February 21, 2019

**Re: MI Treehouse CAO15-001 and SEP15-001 Reasonable Use Exception ESA memorandum
(12-06-2018)
CORE Project No. 18039**

SITE PLAN
5637 MERCER WAY
MI TREEHOUSE, LLC
 11030 SE 30TH ST
 BELLEVUE, WA 98004

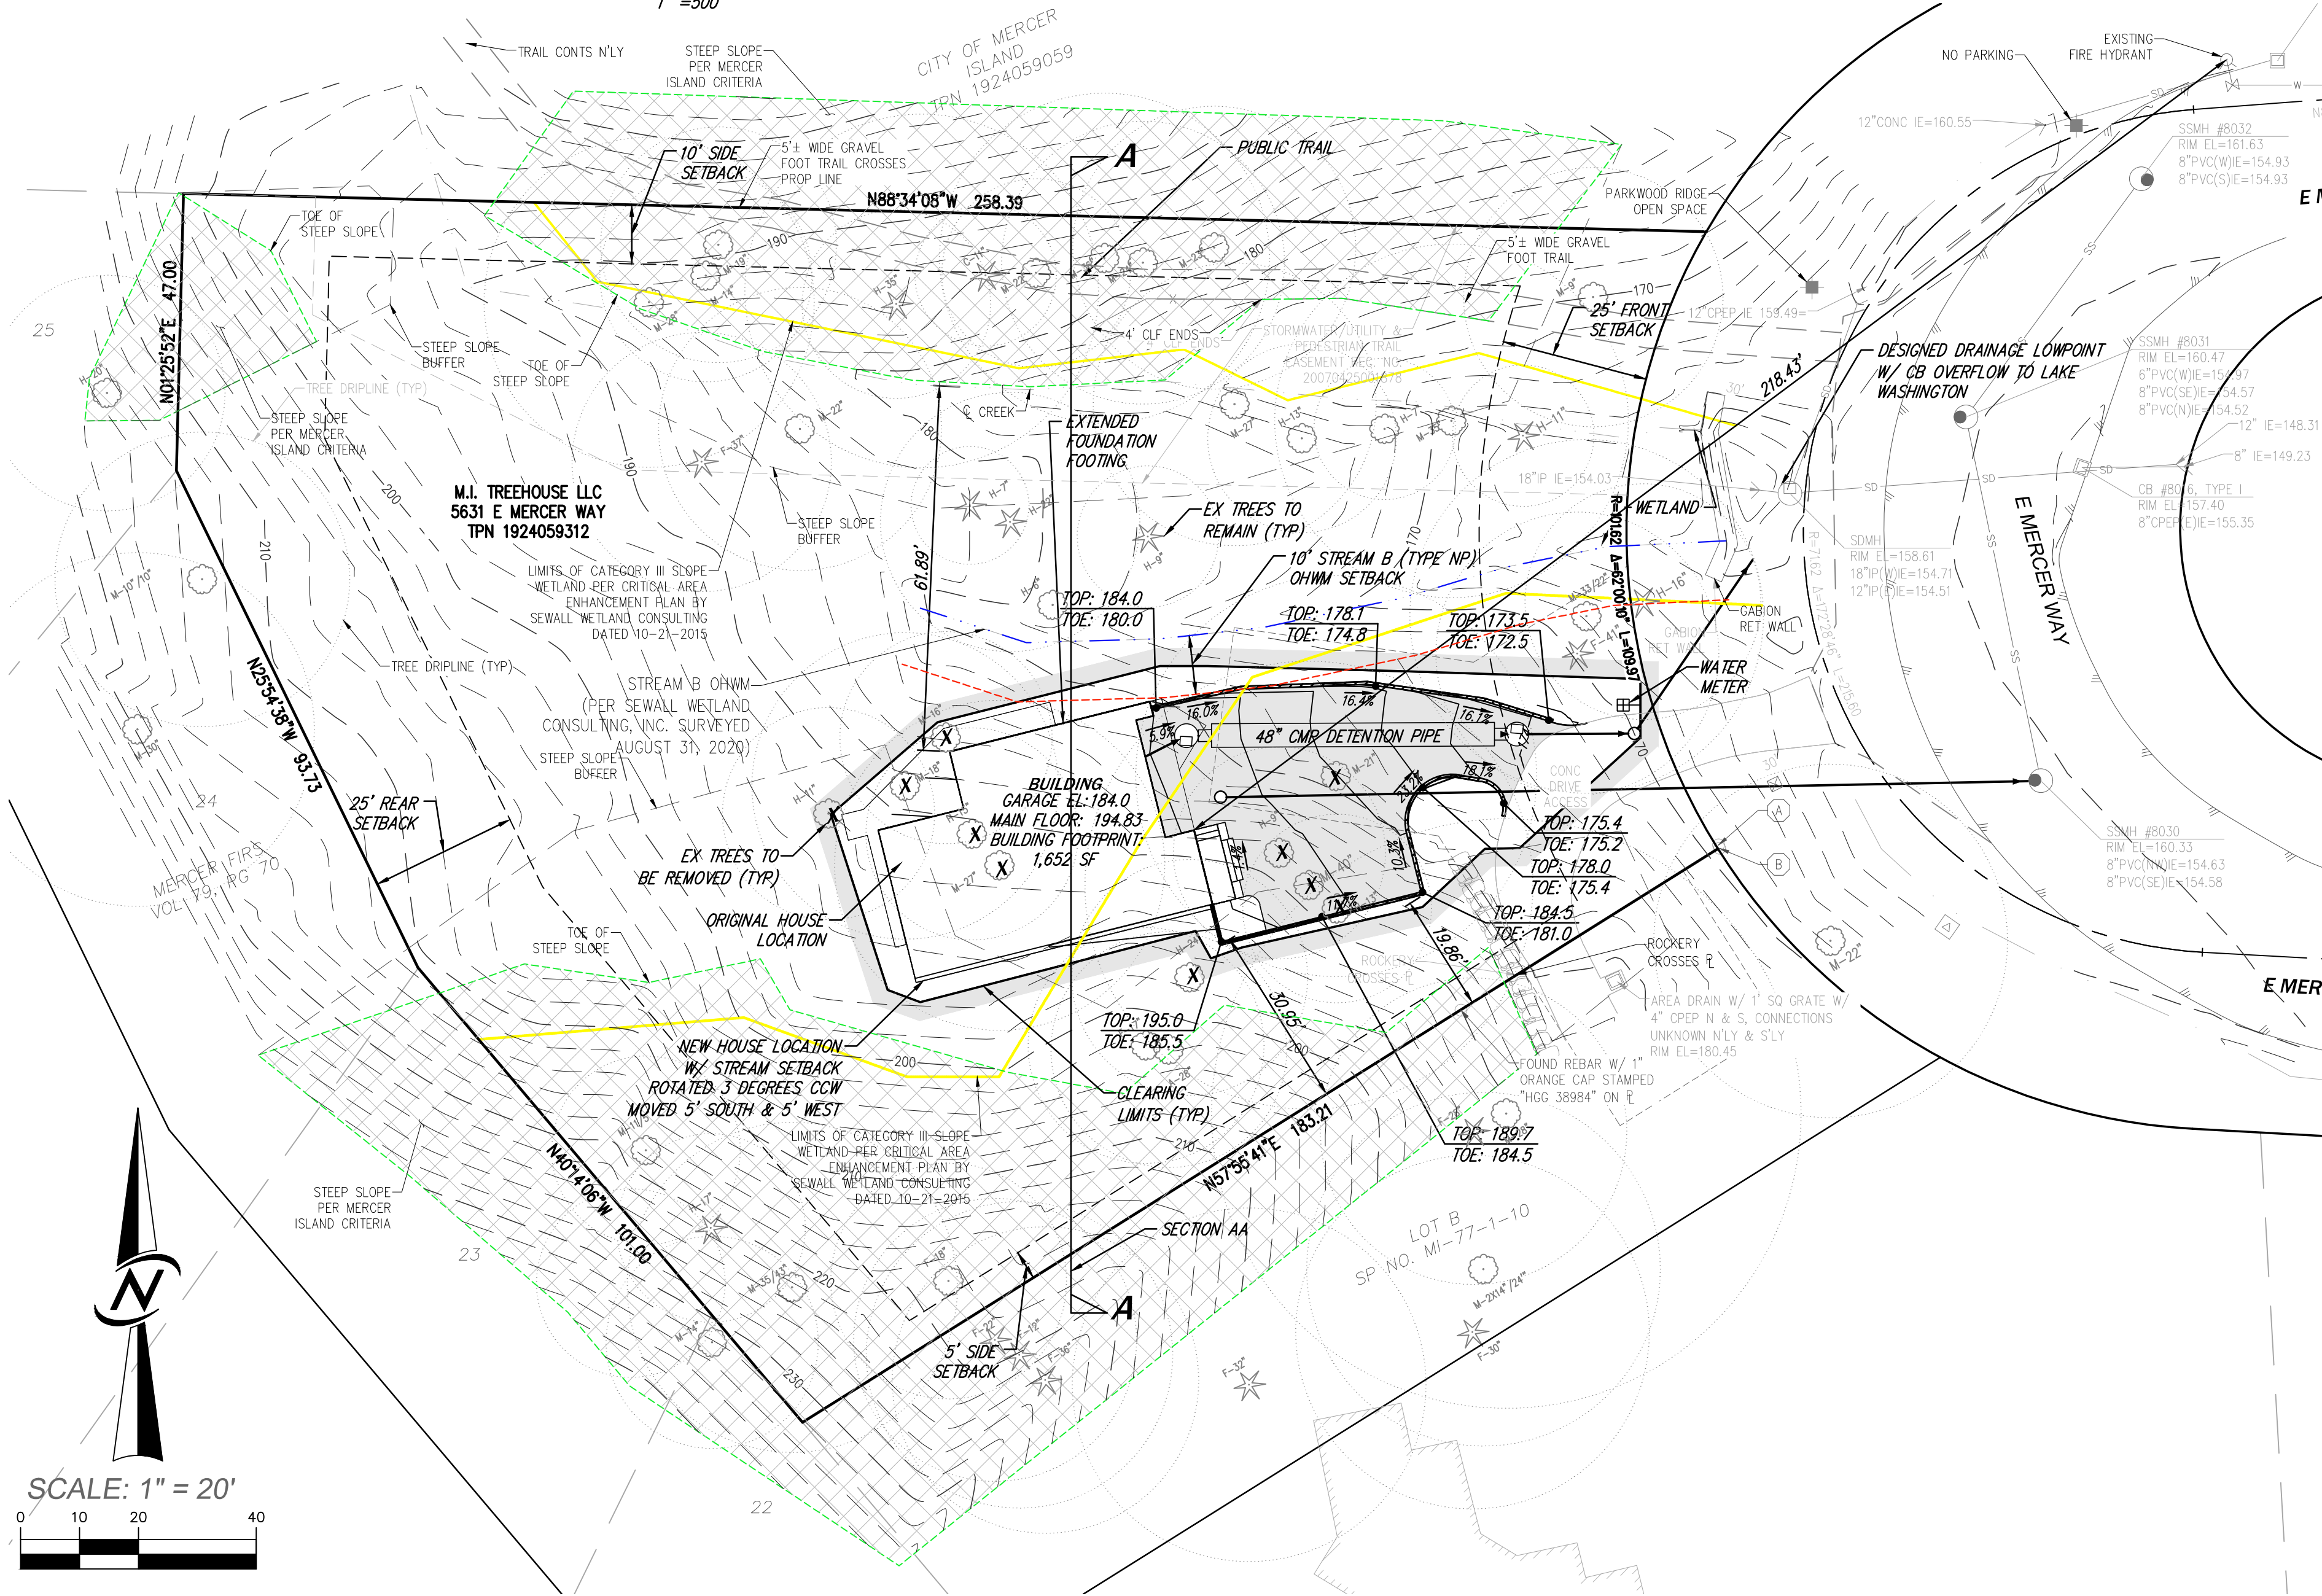
Retaining Walls (Mr. Anderson email, paragraph 2 and ESA memorandum, paragraph 3)

With regard to the retaining walls discussed in paragraph 2 of Mr. Anderson's email and summarized in paragraph 3 of the ESA memorandum, I would agree that (1) shifting the grading design resulting in relocated/smaller walls and/or (2) adding/considering wall drainage (typical of all walls and required during final City review) with specific goals to minimize adverse impact to the surrounding sensitive

Detention System (Mr. Anderson email, paragraph 3 and ESA memorandum, paragraph 4)

With regard to the detention tank system discussed in paragraph 3 of Mr. Anderson's email and summarized/supplemented in paragraph 4 of ESA's memorandum, the project team again agrees that it would be wise to pay close attention to the siting, orientation and sizing for this system so that bypass area is minimized and impact to sensitive areas is optimized including specific consideration for proximity of excavation and permanent placement to existing wetlands/streams. We know there will be impact but a priority goal for the project is to optimize/minimize impact and provide appropriate mitigation where impacts are unavoidable. We would typically expect to work with a hydrogeologist to analyze pre-developed wetland hydrology and design to maintain this in both temporary (during construction) and permanent (fully developed/completed) phases. All design detail demonstrating a Code-compliant design is anticipated during the final design phase of the project.

Bypass Area 1 (Mr. Anderson email, paragraphs 4 and 5)

As noted above the siting, orientation and sizing of the detention system will be optimized to collect as much stormwater runoff as possible in order to minimize bypass area. Mr. Anderson is correct that it is already a challenge to meet pre-developed runoff rates and durations on small sites so having any bypass can significantly add to that challenge. We are familiar with this condition and expect to optimize the design during final engineering. Mr. Anderson is also correct that eliminating bypass area on this project is likely infeasible which is why we will seek to find an optimum condition in the final design.

Flow Control Calculations (Mr. Anderson email, paragraph 6)

In the final paragraph in Mr. Anderson's email he refers to a meeting Core was not present at but appears to have included discussion regarding bypass area in flow control/detention system sizing calculations. For many small projects like this one the detention sizing calculations are indeed different and may or may not include bypass area considerations. However, in our experience on other parcels that are constrained with critical areas and associated buffers, additional analyses are included in the final engineering design to analyze and address concerns related to critical areas and potential adverse impacts from development. However, it has also been our experience that the Reasonable Use process is not a final design level evaluation but that it also does not provide a final design or construction approval. The most appropriate place for such detail is the final design / construction permit process. This is the process in which the owner/applicant demonstrates compliance with all applicable codes, requirements and standards including any site-specific conditions applied during or as a result of the reasonable use process.
